Transport Infrastructure Planning Unit

14 December 2023

**A12 Chelmsford to A120 Widening Scheme (the Project)  
DCO Application  
Further responses to interested parties responding to Secretary of State's Second  
Request for Information dated 20 November 2023**

HE551497 - JAC - LDC - S3_J24 -DR- C -0101

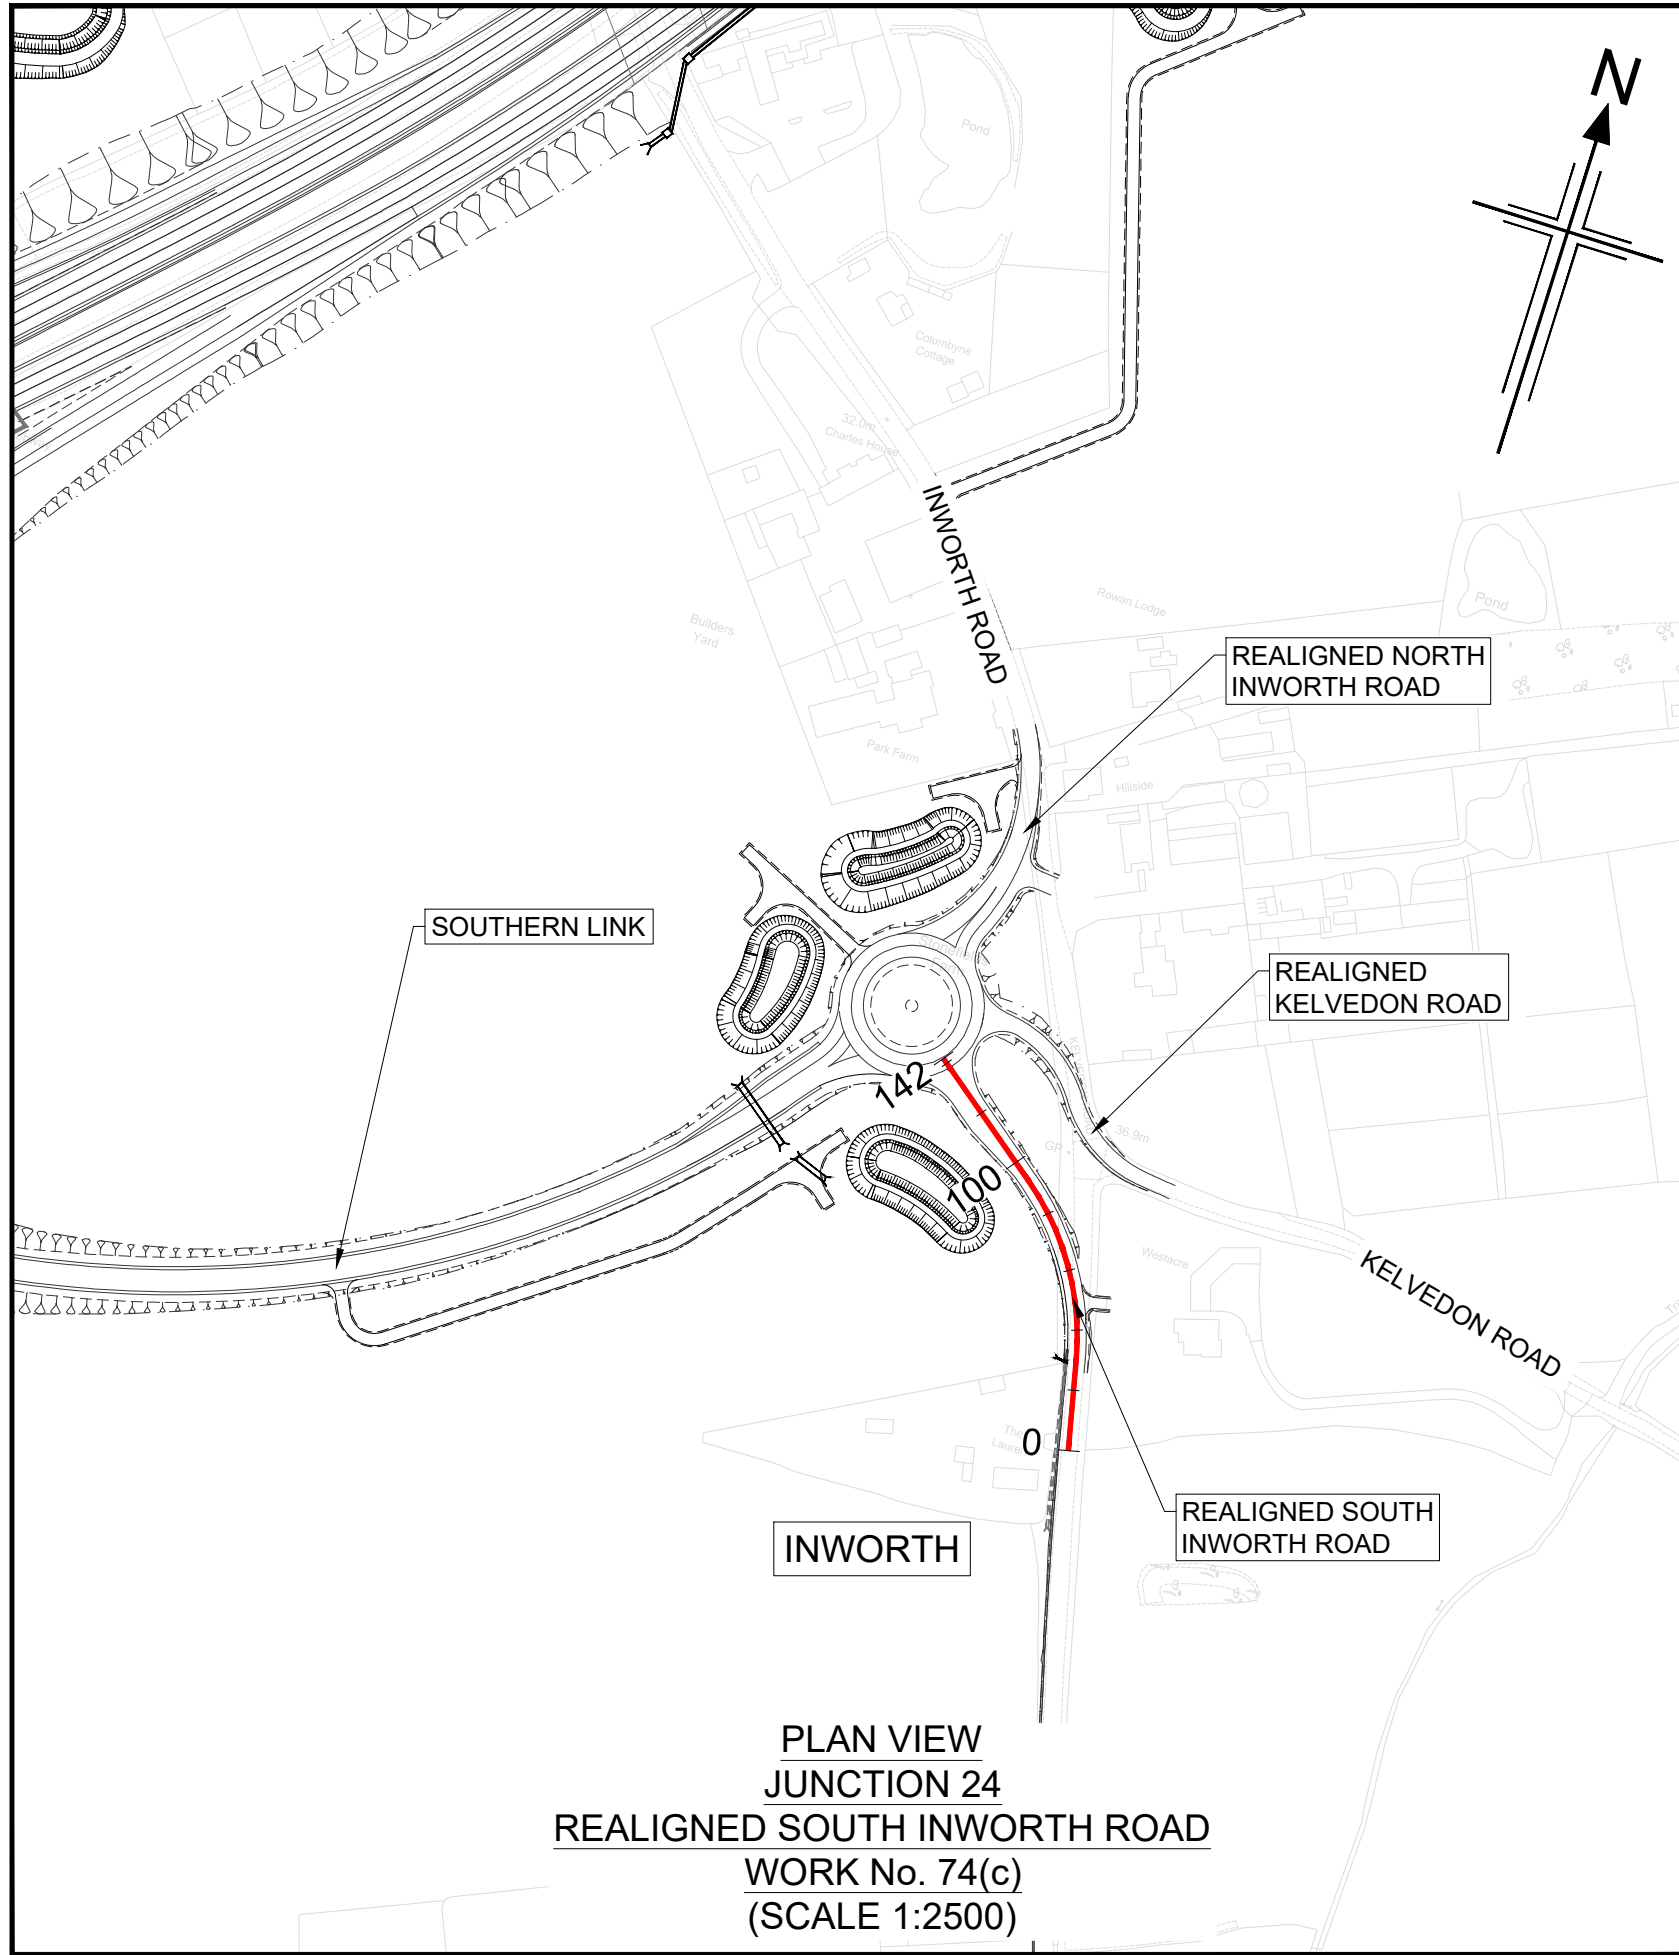
3. a) Braxted Road

The Applicant confirms that vertical alignment details were included on the Highways Engineering Sections Drawings submitted as part of the DCO Application package, showing the constrained location and vertical geometry of Braxted Road Bridge and its approaches. This has been confirmed to the Council in the Applicant's letter of 24

November. ECC has asked for further details and the Applicant continues to liaise with the Council to provide this in a timely fashion as the detailed design becomes available.
